**RE: Del Sol Condos
8300 Comanche Rd. NE
Grading & Drainage Plan
Engineer's Stamp Date: Not Stamped/ Dated
Hydrology File: G19D003A**

Based upon the information provided in your submittal received 01/16/2025, the Grading & Drainage Plan is **not** approved for a Grading Permit or Building Permit. The following comments need to be addressed for approval of the above referenced project:

DEL SOL CONDOS
DRAINAGE ISSUES
CONSTRUCTION DOCUMENTS
PROPOSED DRAINAGE PLAN

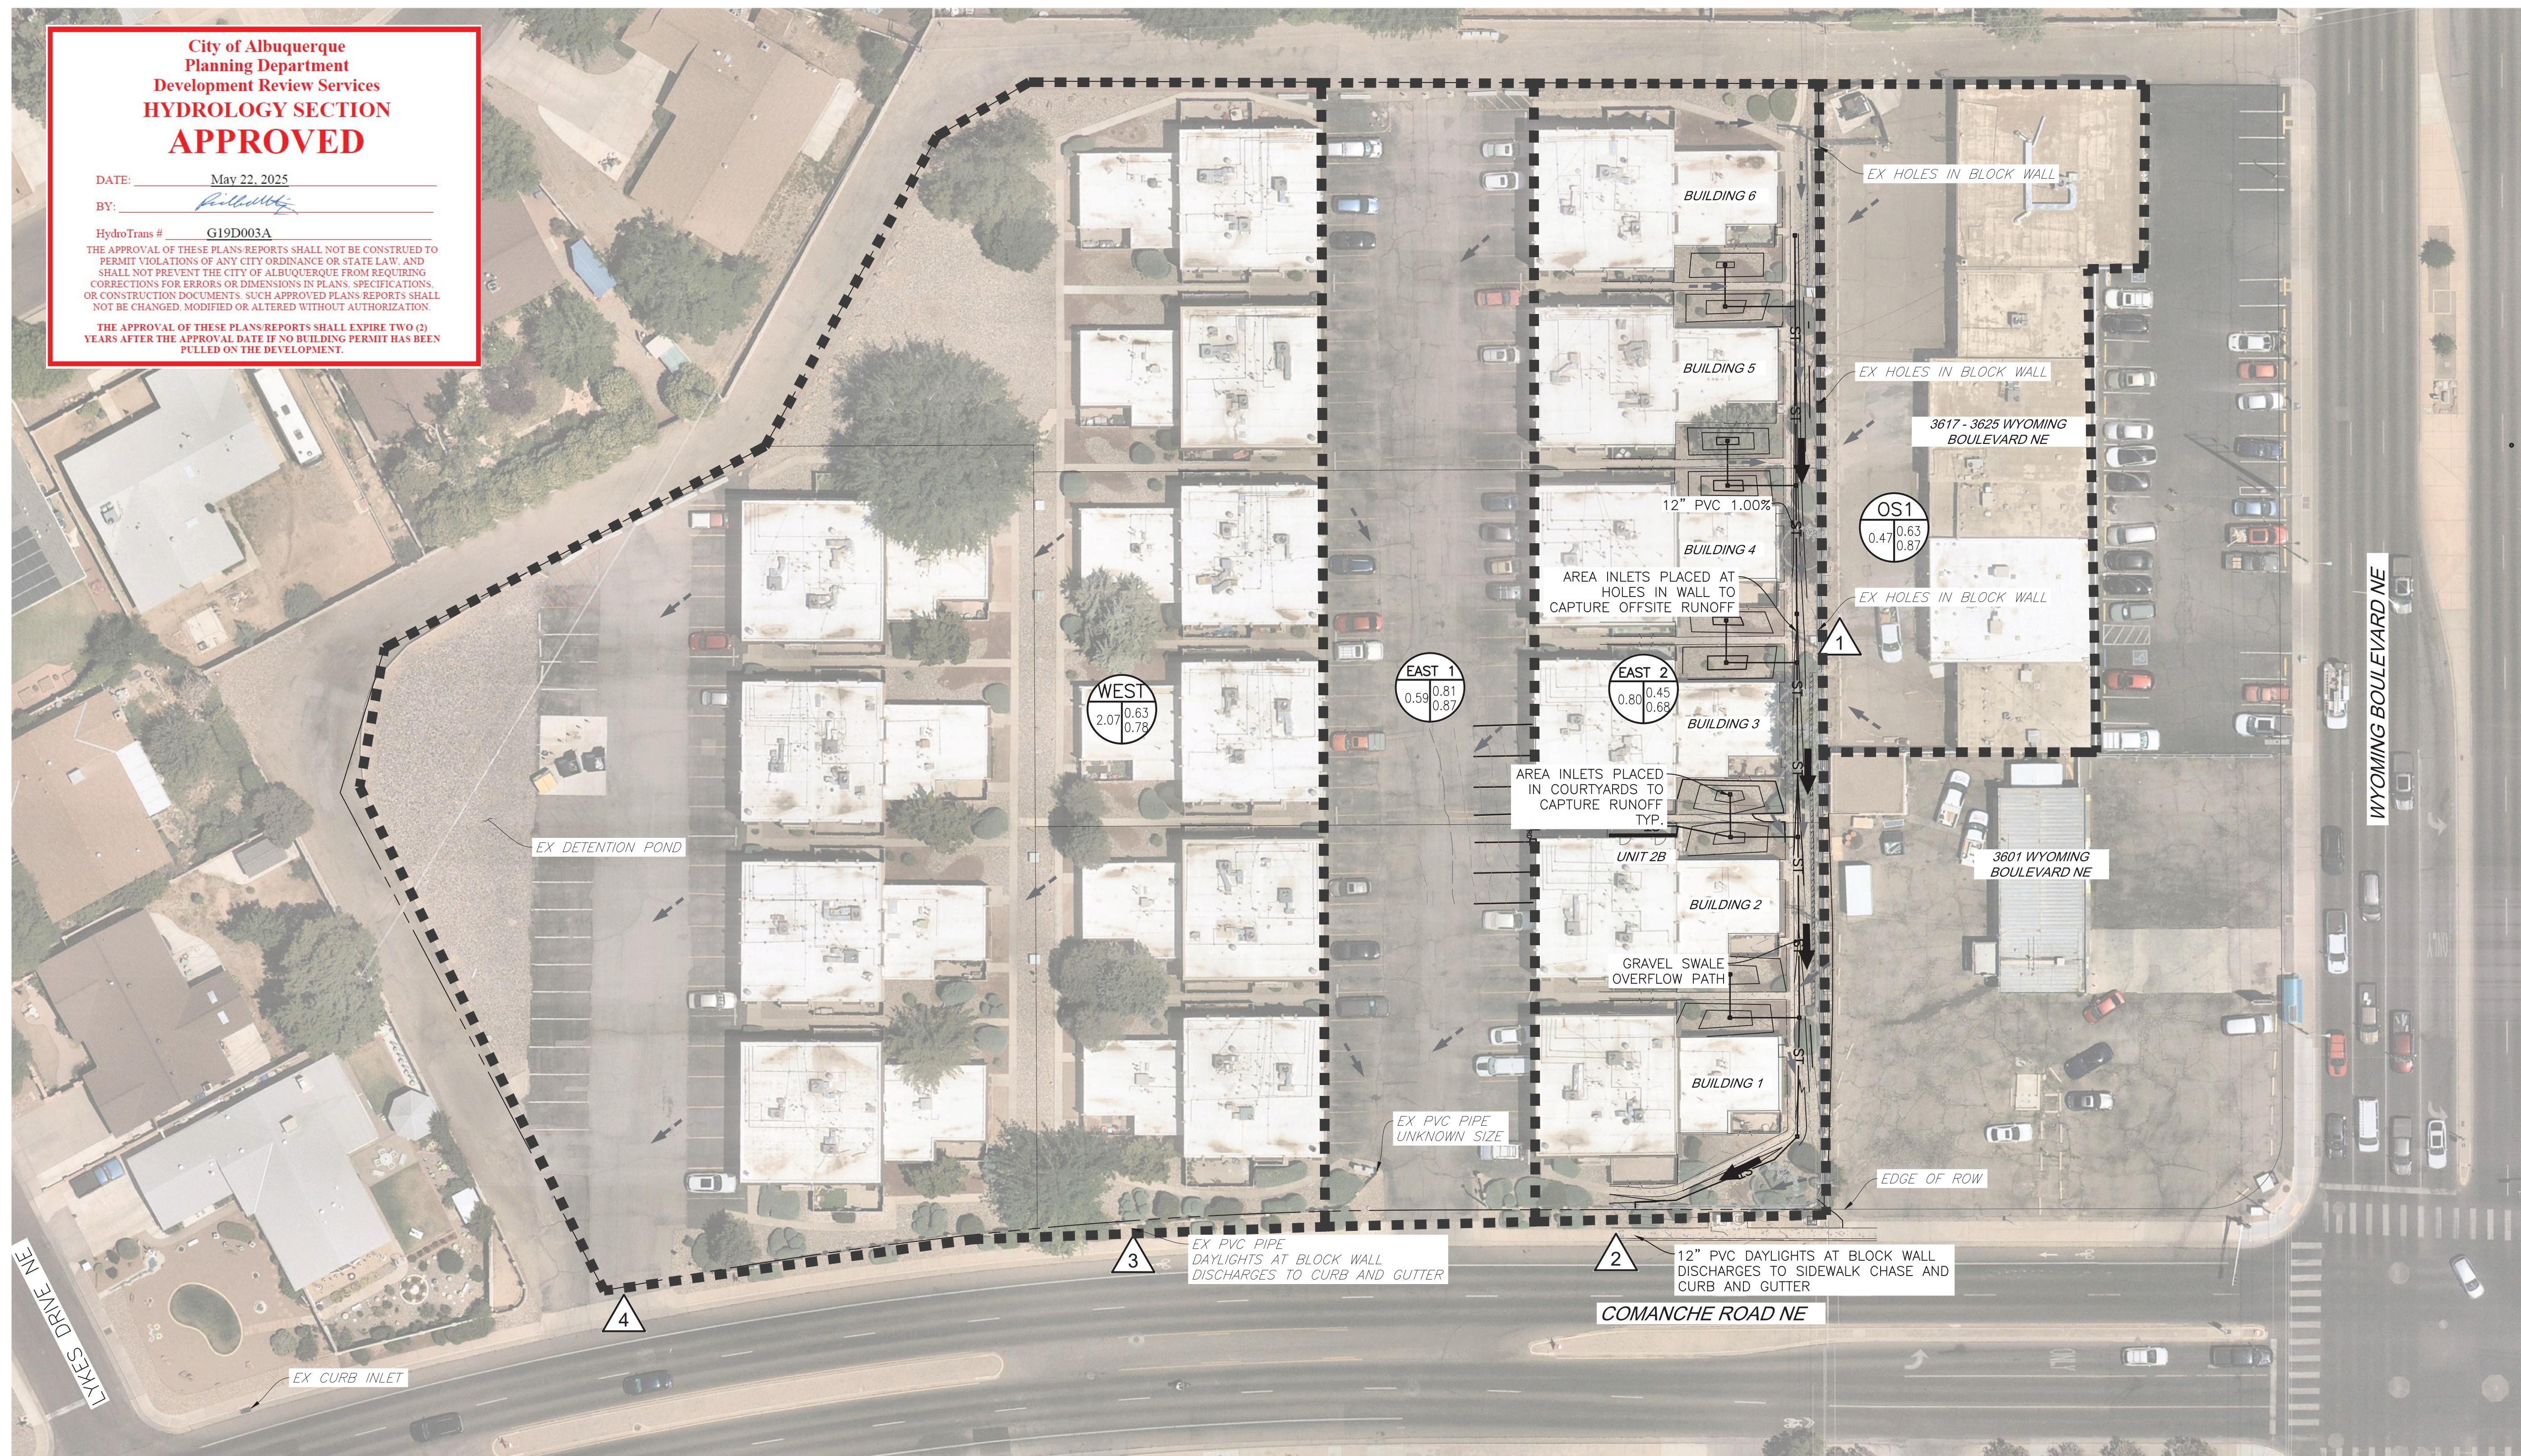
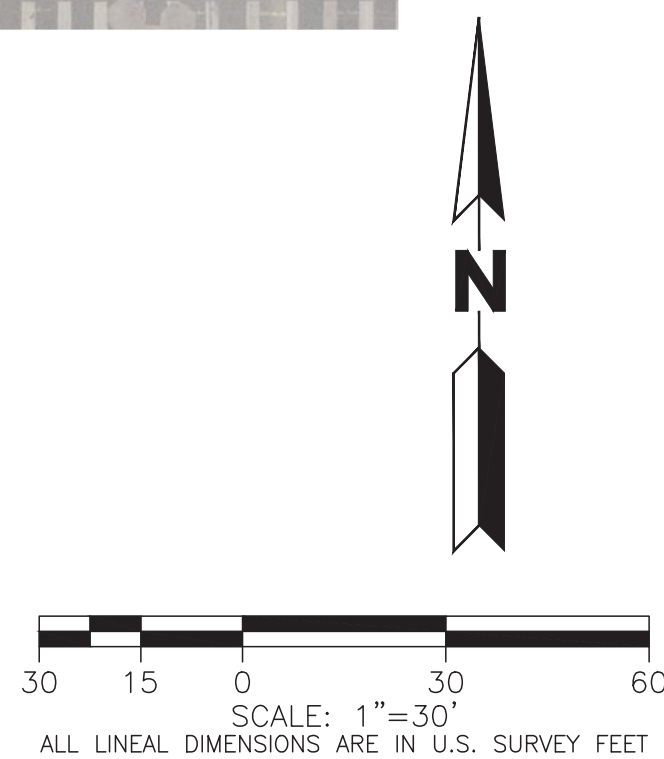
3. Provide management onsite for the Stormwater Quality Volume (SWQV) in accordance with the new drainage ordinance, § 14-5-2-6 (H). Please show the top and bottom of the ponds along with the volume for each pond. The onsite drainage should be directed to these ponds prior to being collected in a private unground drainage system. Please follow the DPM Article 6-12 Stormwater Quality and Low-Impact Development for the sizing calculations. To calculate the required SWQV, multiply the impervious area draining to the BMP by 0.42 inches for new development sites and 0.26 inches for redevelopment sites. The calculations of both the required and the provided volume of each BMP must be shown on the Grading and Drainage Plan. Each BMP should be labeled on the Grading and Drainage Plan with the required SWQV and associated water surface elevation and the 100-year water surface elevation. Landscaping of surface BMPs is also required to be noted on the Grading and Drainage Plan.

4. Please number the ponds and include a label on each with the SWQV and elevation, the 100-year volume and elevation, the peak 100 year inflow and outflow, the drainage elevation, and the ponding depth.
5. Please provide the SWQV calculations for each basin draining to each pond. The stormwater quality ponds need to be sized for the areas draining to them.
6. To prevent or mitigate debris from clogging the proposed grated inlets, round beehive grate inlets should be considered at the bottom of the proposed detention ponds.
7. Prepare and provide a response to each of the above items in a subsequent re-submittal for further review.
